WEST SUSSEX COUNTY COUNCIL CONSULTATION

TO:	Arun District Council FAO: Jonny Cooper
FROM:	WSCC – Highways Authority
DATE:	9 April 2026
LOCATION:	95 Longford Road, Bognor Regis, PO21 1AE
SUBJECT:	BR/27/26/HH Dropped kerb and new vehicular access.
DATE OF SITE VISIT:	n/a
RECOMMENDATION:	Advice

PROPOSED NEW VEHICULAR ENTRANCE AT 95, LONGFORD. ROAD, BOGNOR REGIS
FOR MR. & MRS. S. BAKER - BROWN.

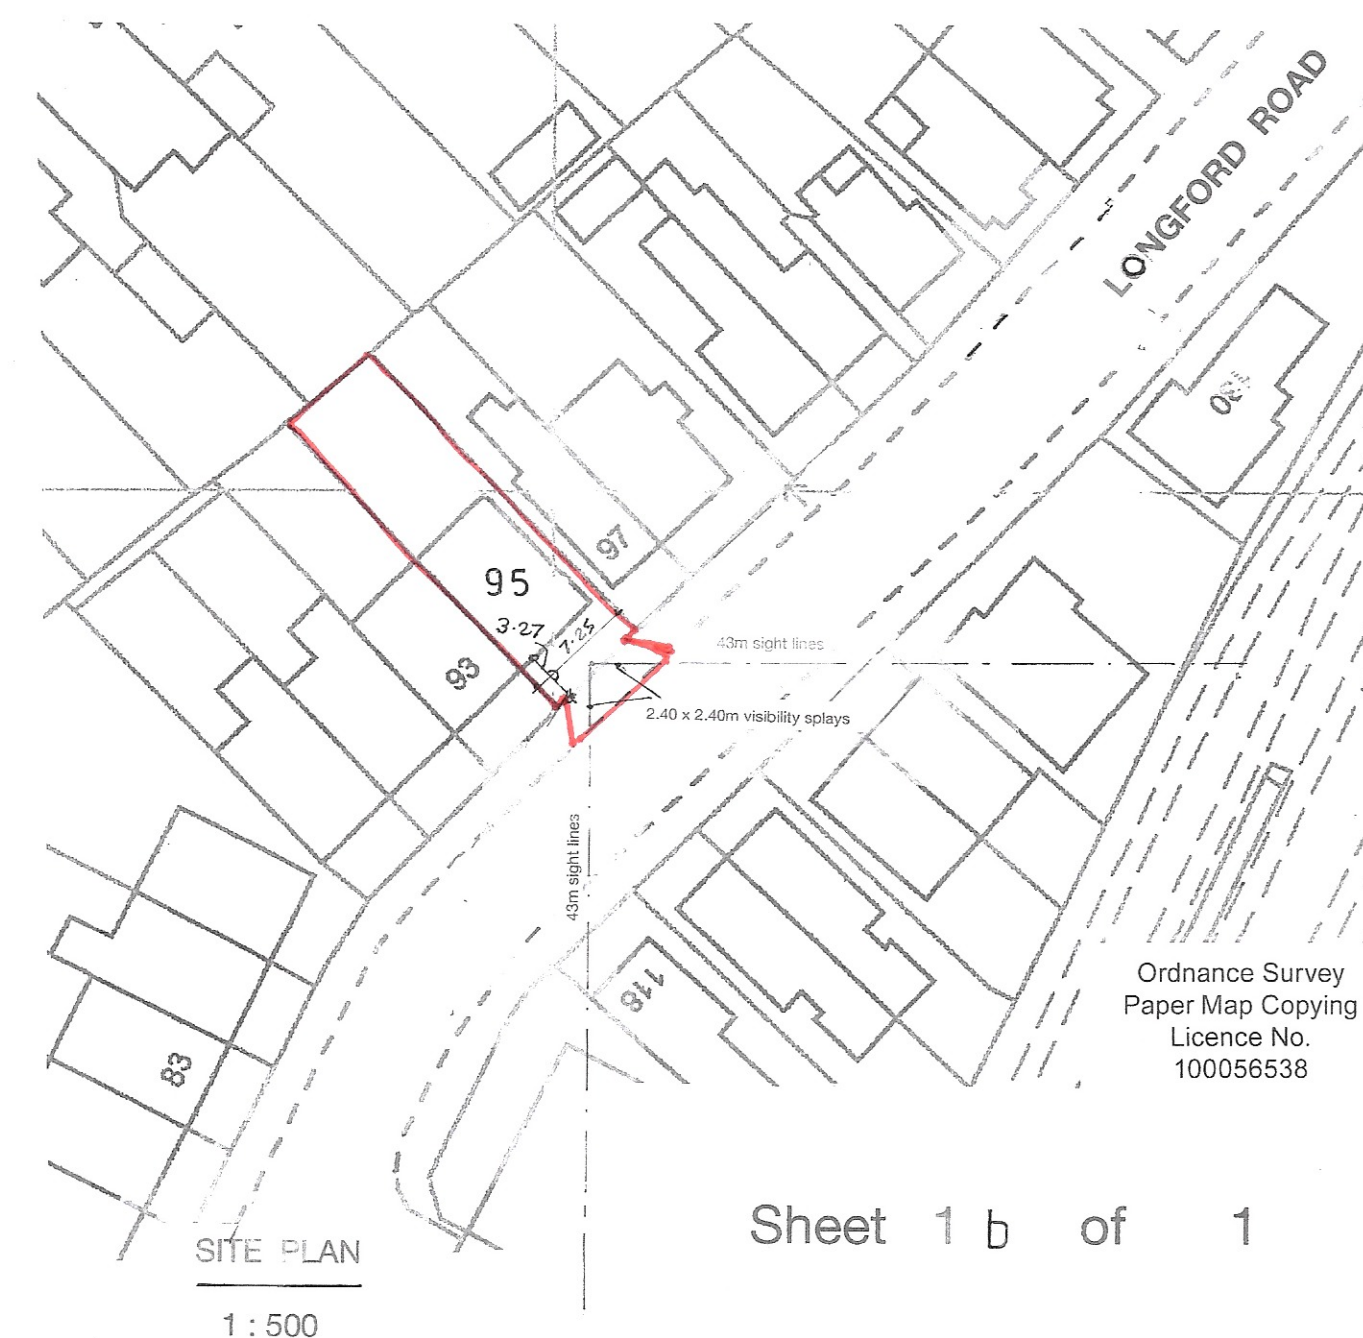
From inspection of the plans, there are no apparent visibility concerns with the proposed access point. The proposed access works including relocation of existing bollard would be subject to a licence obtained through the local WSCC Highway Area Office and constructed to a specification agreed with the local WSCC Highway Area Engineer.

I note that under current Highway Area Office guidance for Vehicle Crossovers (VCOs), licences are only granted for accesses with hardstanding depths of at least 4.8m. The submitted plans demonstrate a hardstanding depth of 3.27m, which is too small to accommodate a parking space of 2.4m x 4.8m. Therefore, the applicant should be advised that a licence for the proposed access works is unlikely to be granted.

Therefore, whilst no highway safety concerns would be raised for the proposals, the applicant should be made aware that they are unlikely to be granted a licence for the proposed access works, as the proposals are contrary to current WSCC Area Office policy.
